From: [REDACTED]
Sent: 20 August 2026 09:27
To: Susan Haley
Subject: Re: EP/68/26/HH - 8 Tamarisk Way, East Preston

I am currently reviewing application EP/68/26/HH - 8 Tamarisk Way, East Preston and would be grateful for clarification on the proposed materials.

Proposed Elevations

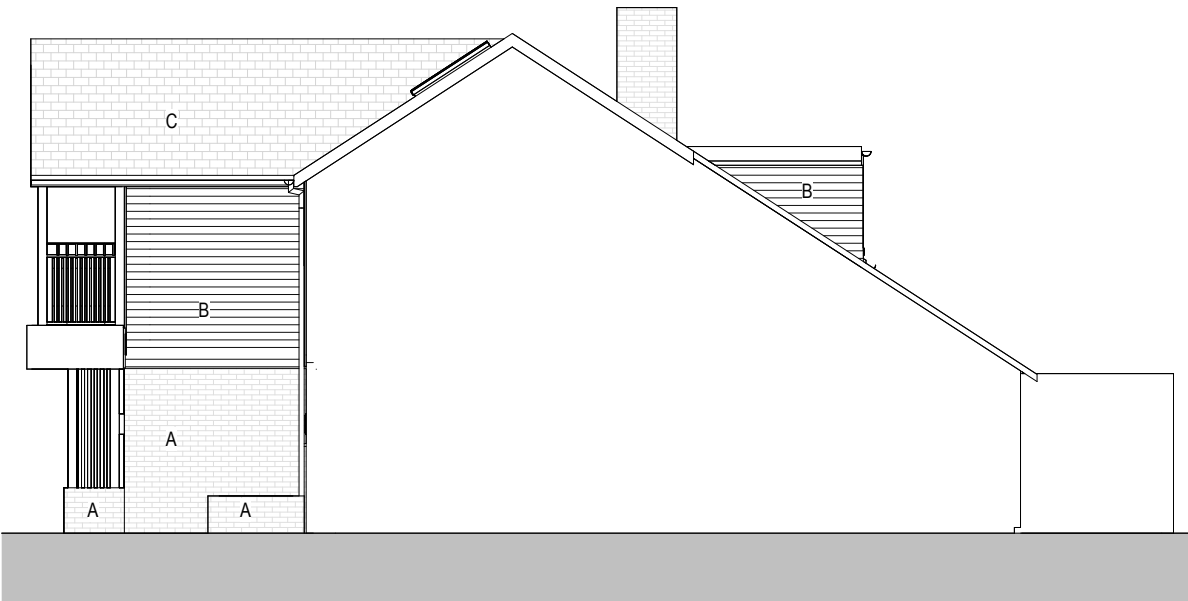
In particular, could you confirm whether the roof tiles proposed for the two-storey front extension will match the existing roof tiles on the host dwelling, the proposed colour of the replacement window frames (e.g. white or coloured uPVC), and the proposed materials for the porch pillars and balcony balustrade.

Could you confirm whether the roof tiles proposed for the two-storey front extension will match the existing roof tiles on the host dwelling - **Yes, the roof tiles will match the existing roof tiles**

The proposed colour of the replacement window frames (e.g. white or coloured uPVC) - **The replacement window frames will be in white uPVC**

The proposed materials for the porch pillars and balcony balustrade - **The proposed materials are white aluminium/timber bars for both posts and railings**
